From: John Letton [REDACTED]
Sent: 23 September 2014 05:09
To: Janice Chapman
Cc: Mike
Subject: 37 Stempswood Way

From: Nikolas Antoniou
Sent: 03 September 2014 11:11
To: Janice Chapman
Cc: Daniel Vick
Subject: EG/44/14/PL - 37 Stempwood Way

From: John Letton <[REDACTED]>
Sent: 20 August 2014 15:47
To: Janice Chapman
Cc: michael mascarenhas
Subject: Re: EG/44/14/PL - Extension at 37 Stempswood Way, Eastergate

Proposed Ground Floor Plan

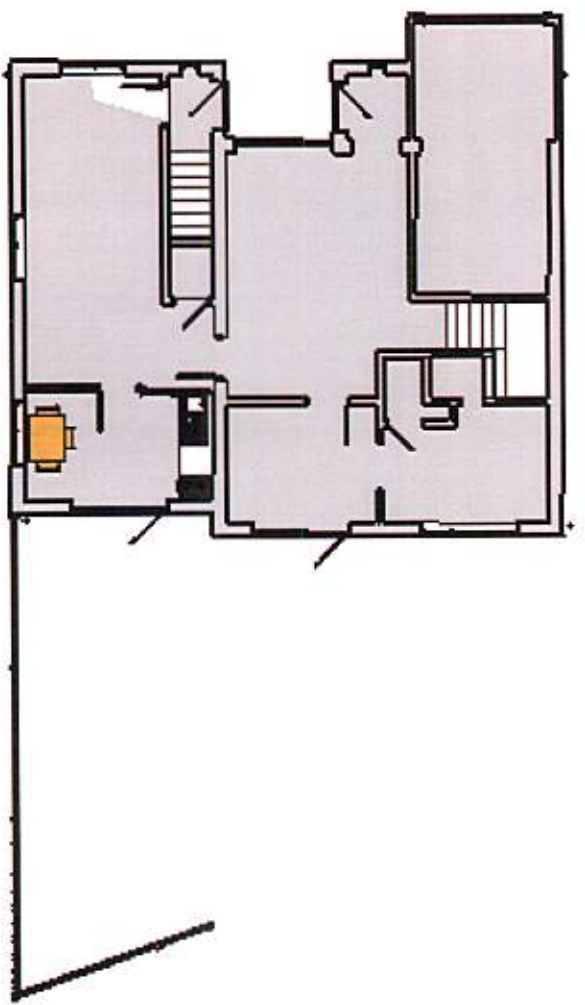
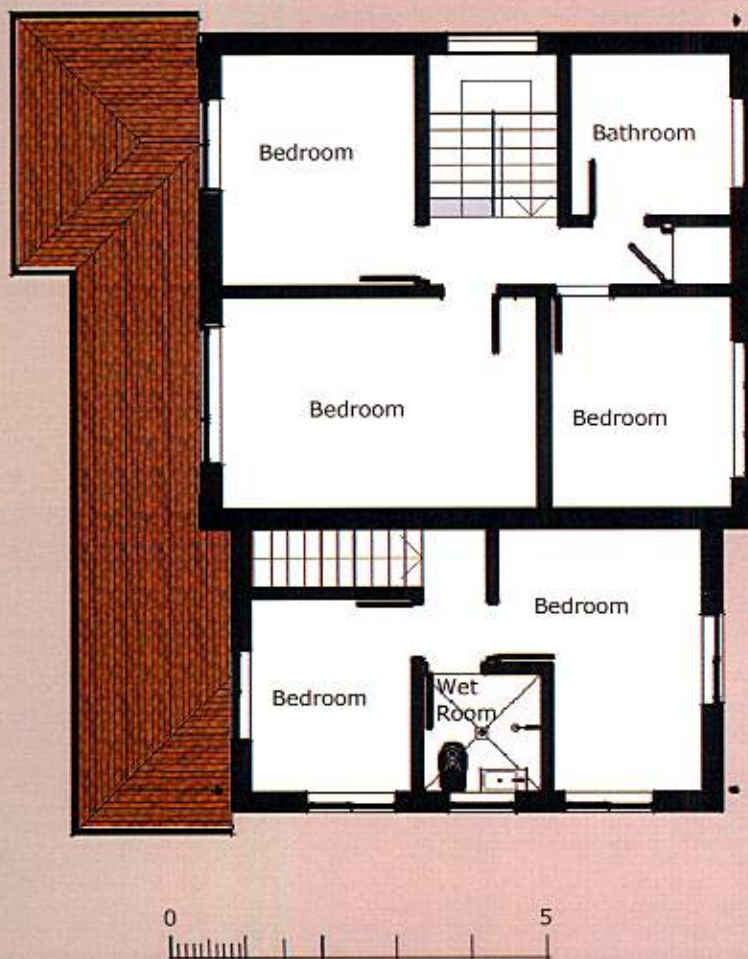
It is clear from the fact that the proposed extension has a separate front door and from the comments from the sister living in the property that the long term intention is to create a separate unit of accommodation. I note you have got an internal door for access in revised plans

If it is an extension then I want to see the proposed front door etc. removed and it appears as a normal extension

As there are no windows on the existing side elevation, the introduction of windows at ground and first floor level would look directly onto the highway. As the ground floor windows serving the living room and kitchen and two bedroom windows are ancillary windows could these be removed.

1. The carer for the Autistic adult who will live there has independent access which is essential to avoid disrupting the family.
2. There is an alternative fire escape avoiding passage through an inner room. This to comply with building regs.

I have spoken with the client and he confirmed that he would like to put a door between the two units at ground level.
